DESIGN AND ACCESS STATEMENT

50 King Street,
Clitheroe

Planning Application submission for
Proposed Rebuilding of Rear Steps and Garage Alterations.
Job No: 2326 - 23.06.2017

IWA Architects

▼ 75.00m above OS Datum

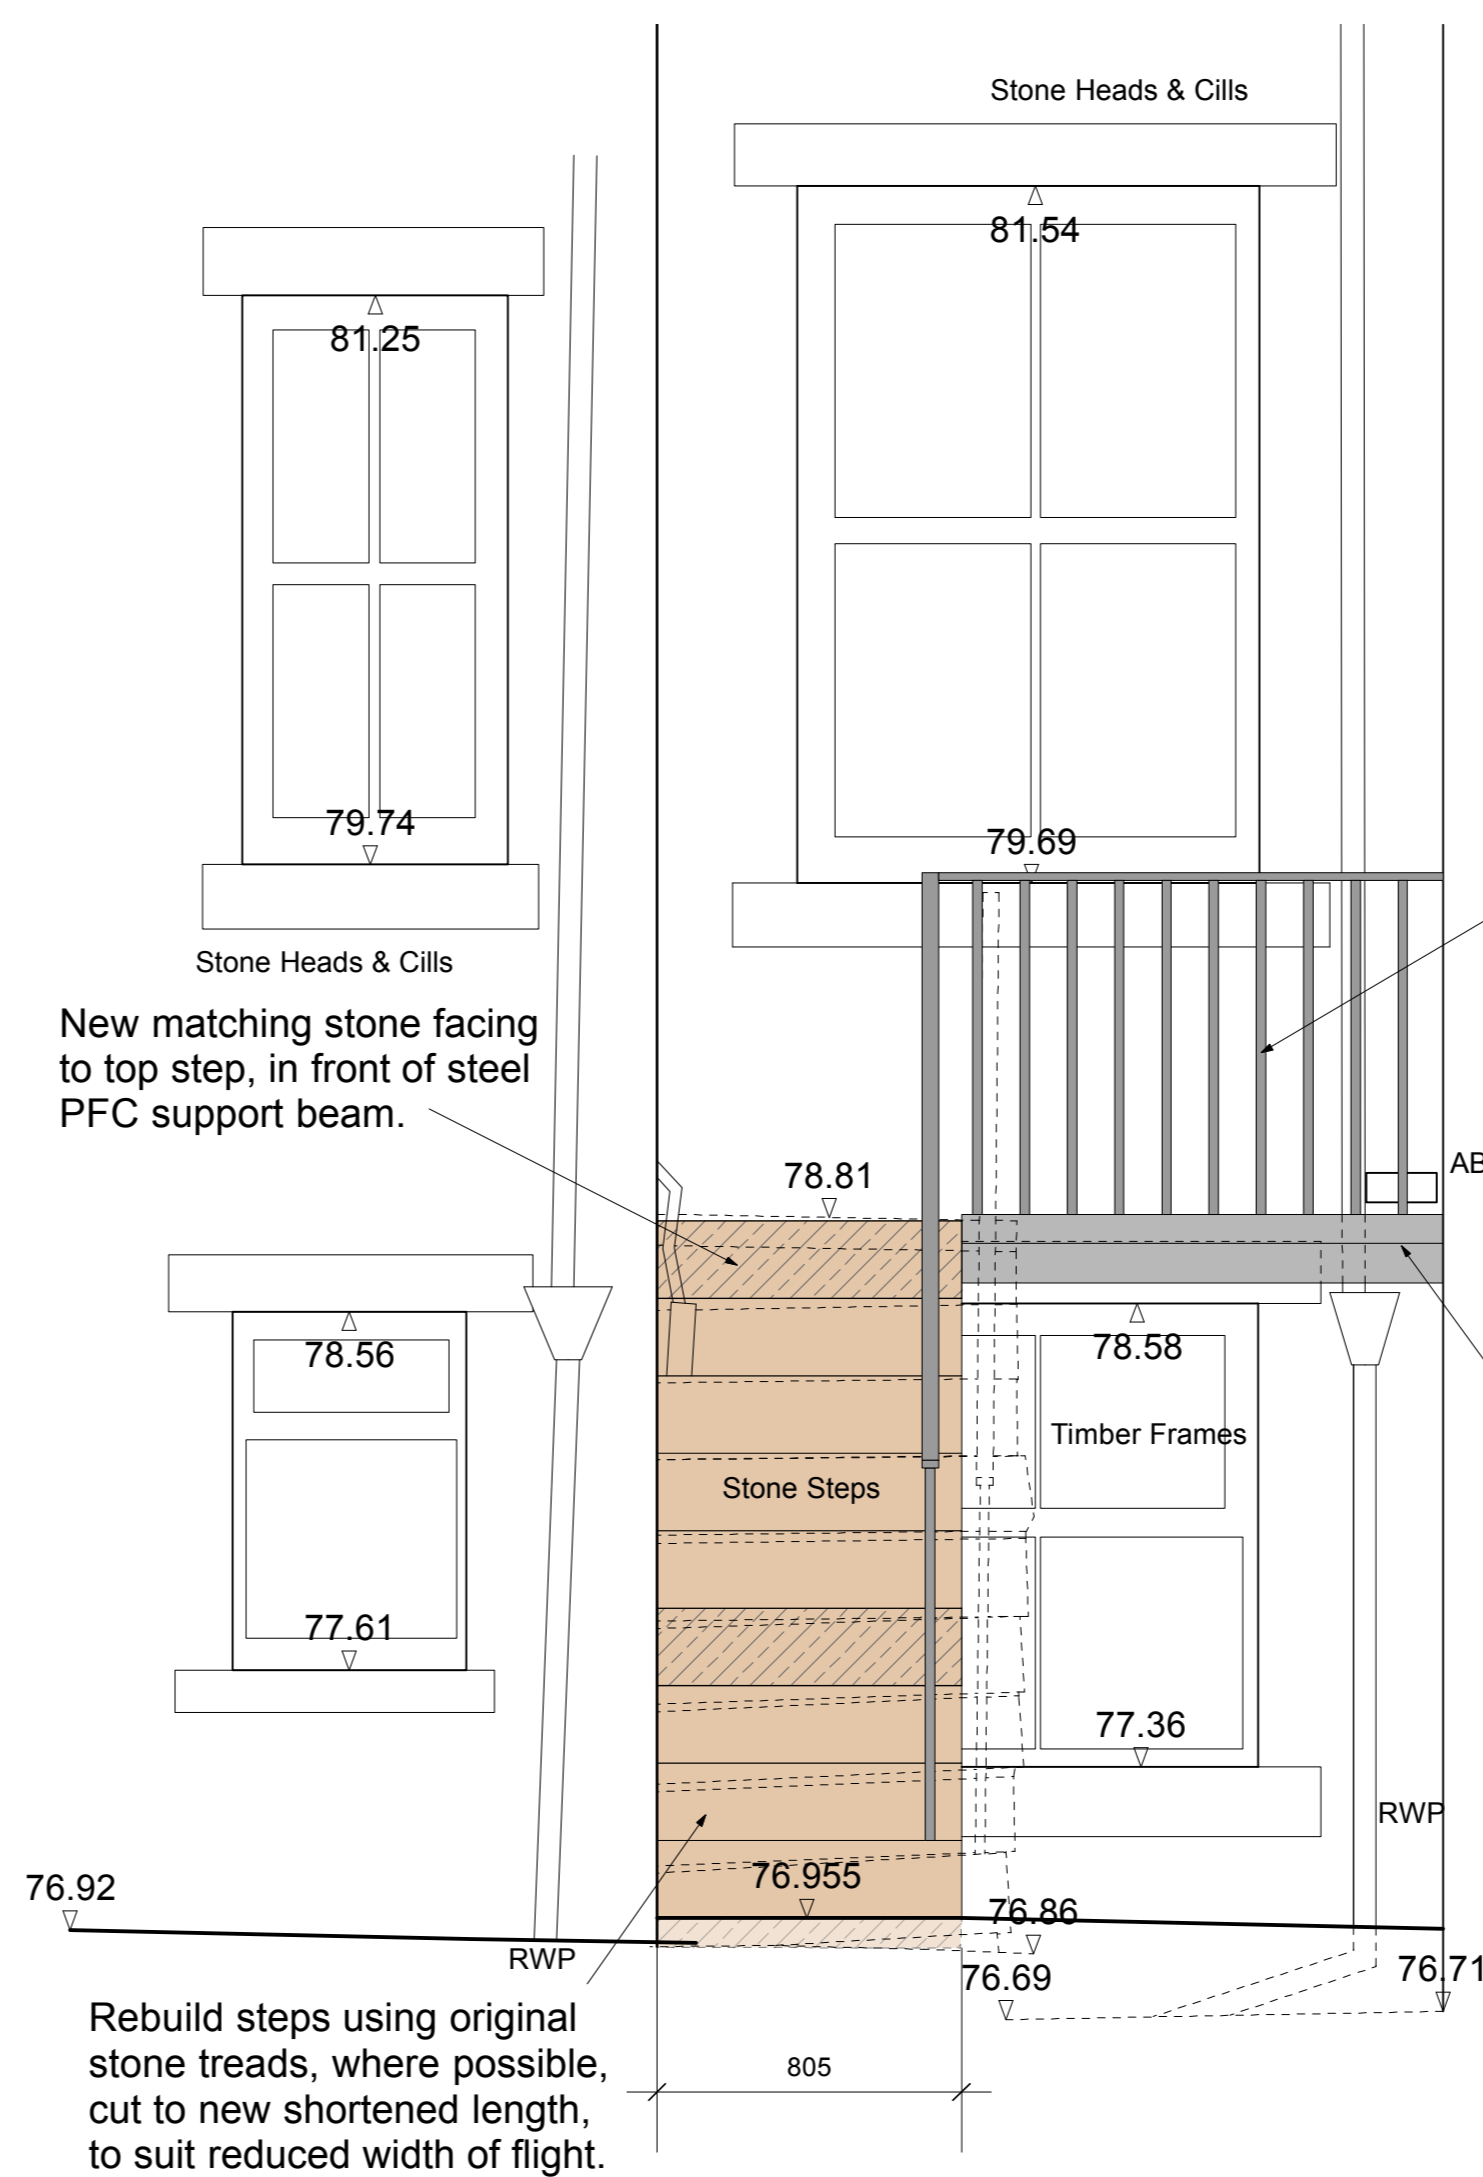
"... I have no objection in principle to the works that are proposed to the rear elevation of the property to create a new stairwell, landing and balustrade. I have no objection in principle to the replacement of the sloping roof to the garage with a pitched roof however not of the height proposed. In my opinion, the height of the building as a result of a replacement pitched roof should be no more than 3 metres. Materials to the
